From: Neville, Julie <Julie.Neville@lancashire.gov.uk>
Sent: 17 June 2025 15:59
To: Maya Cullen
Subject: 3/2025/0284 Little Town Farm Chipping Road Thornley PR3 2TB
Attachments: PRoW Overlay.pdf

Reference 3/2025/0284

Location Little Town Farm Chipping Road Thornley PR3 2TB

Proposal Alterations to vehicular access from Chipping Lane to include widening of access track, creation of pedestrian footpath and erection of fencing.

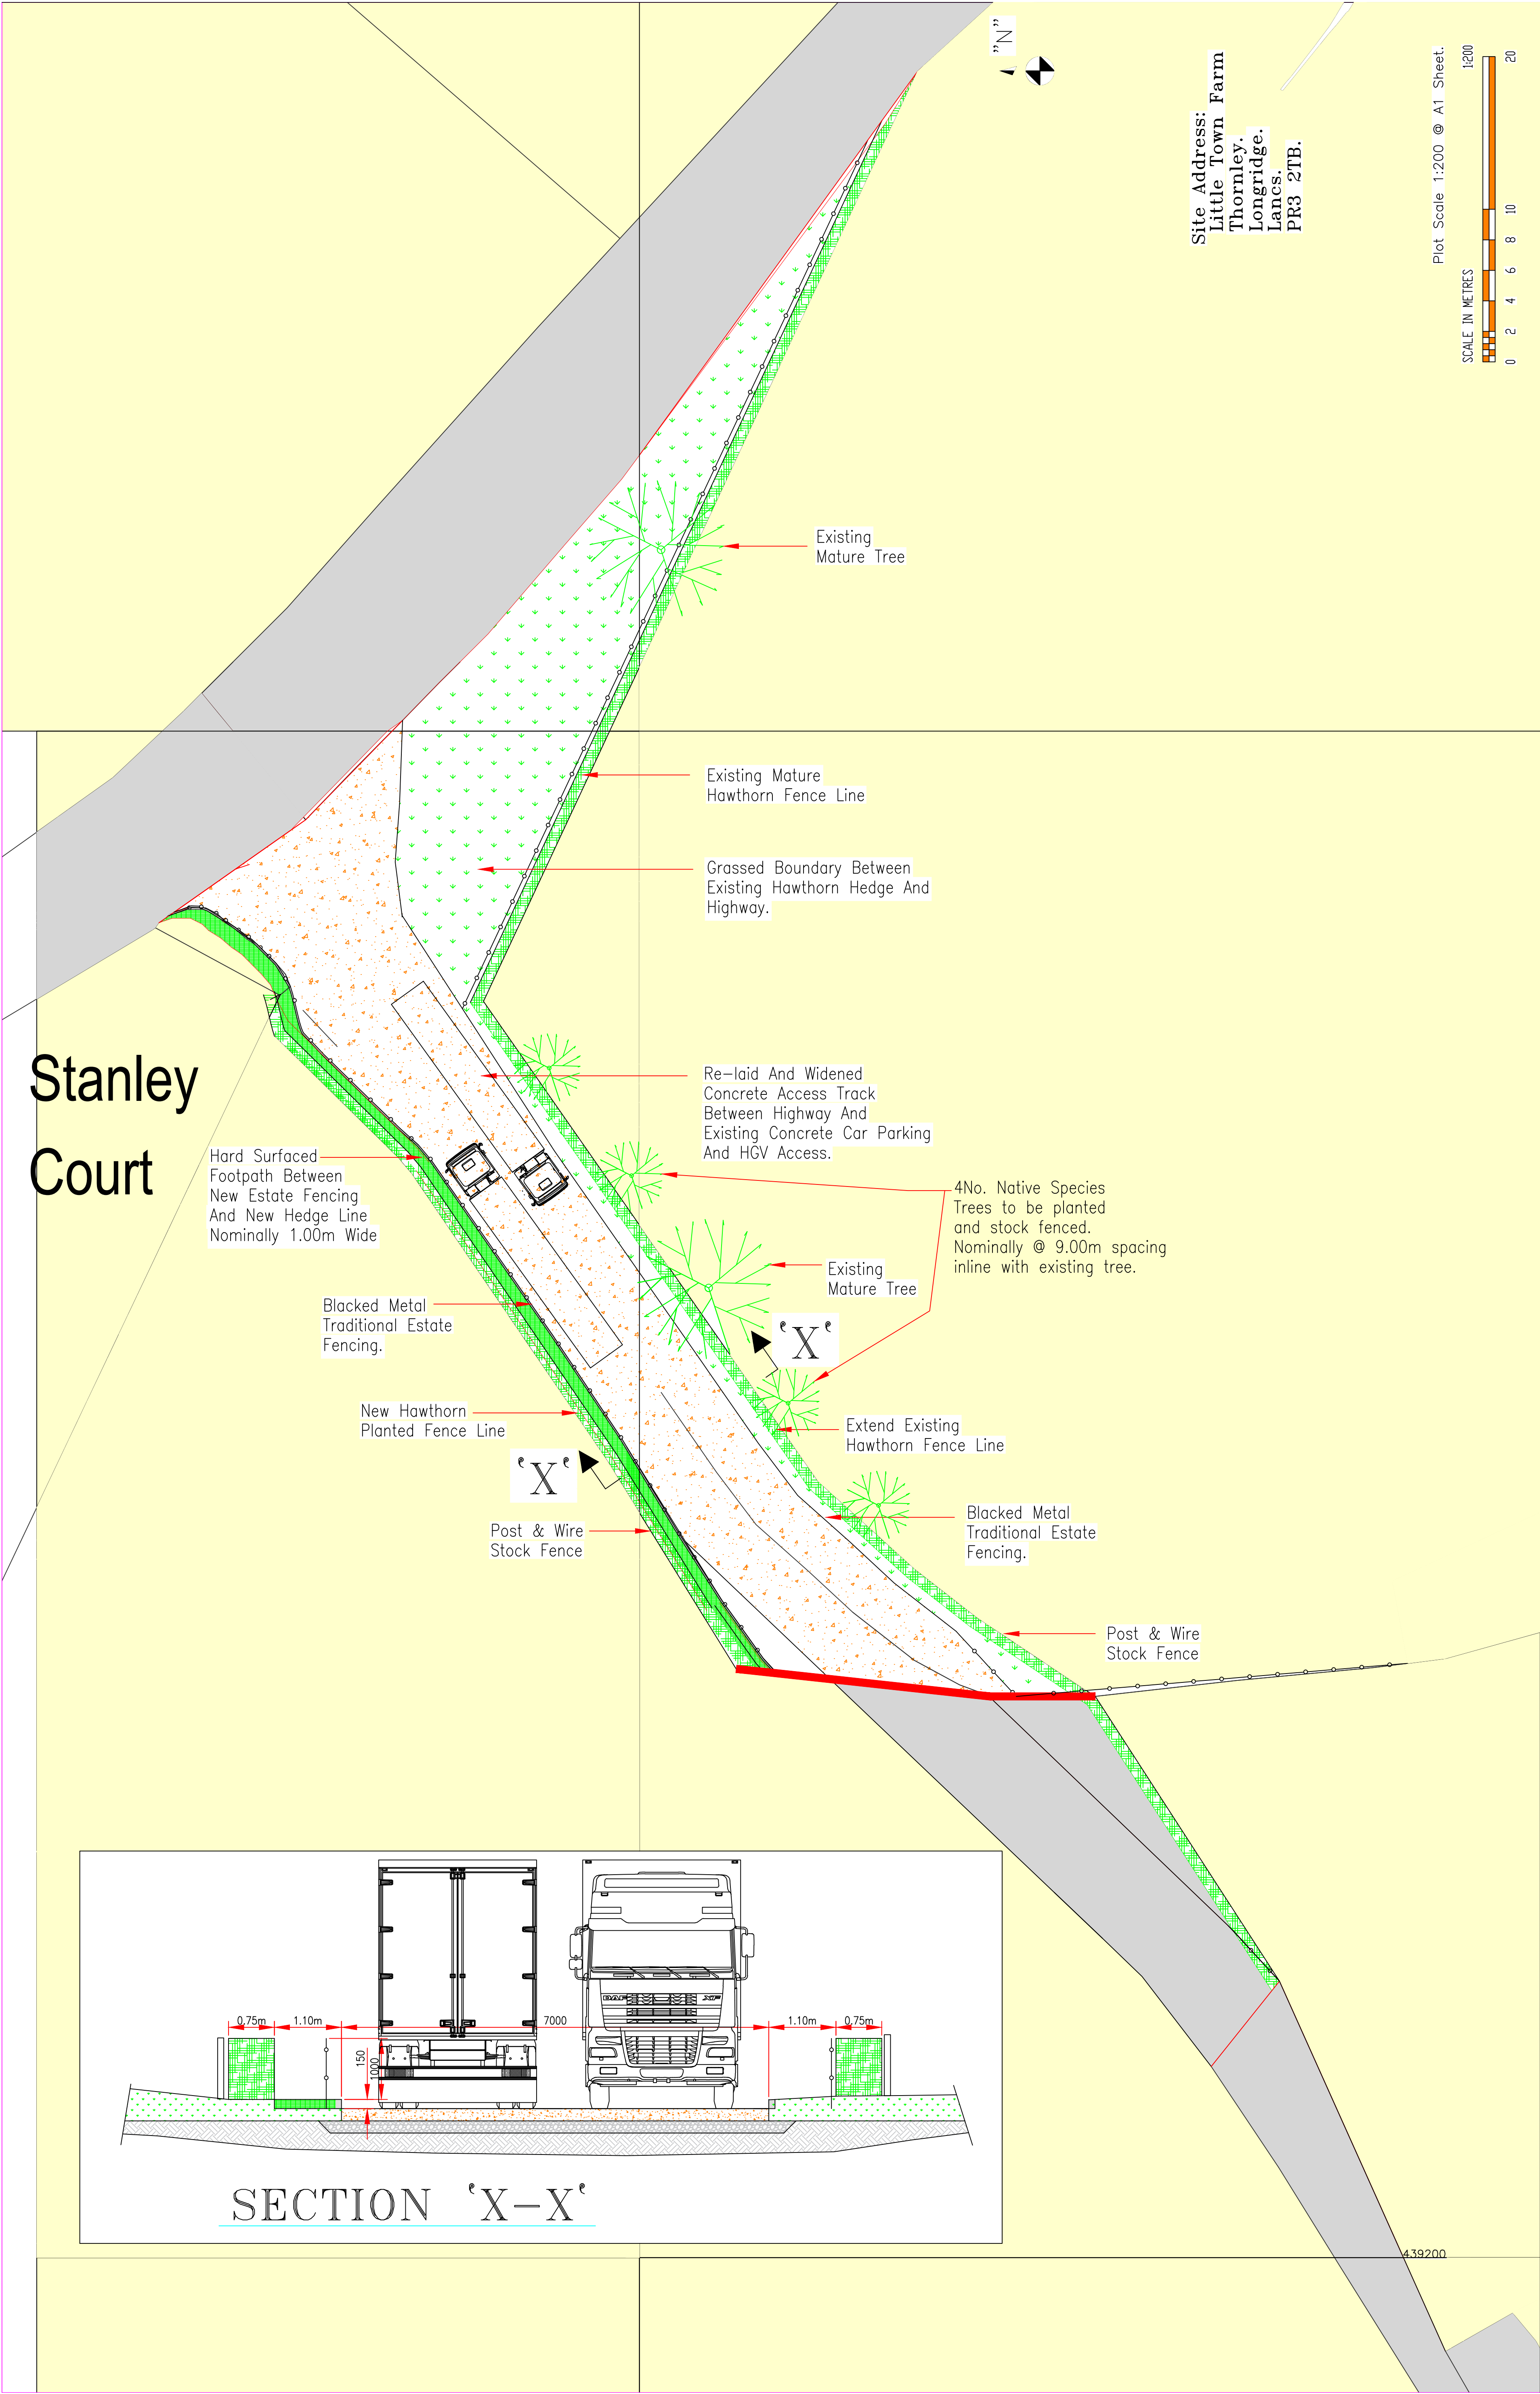
The proposed alterations to the track will obstruct footpath FP0341026 causing a conflict between footpath users and HGVs, as shown on the attached overlay, requiring a Public Path Order under the provisions of the Town and Country Planning Act 1990 Section 257 (TCPA90 S257). TCPA90 S257 orders are administered by the authority that is considering, or has granted the planning permission, in this instance Ribble Valley Borough Council.

The site plan shows the new path to be at a reduced width of 1meter, which is not acceptable. The minimum usable width of the footpath must be 2 meters between the hedge and the fence finished with a compacted stone or tarmac surface . The detail of the exact alignment of the new route, the construction specification and any association works would need to be agreed with the Public Rights of Way Team before the necessary TCPA90 S257 Order is applied for to the local planning authority. **It is for the Owner/Applicant to apply to the planning authority to make a Diversion or Stopping up Order.**
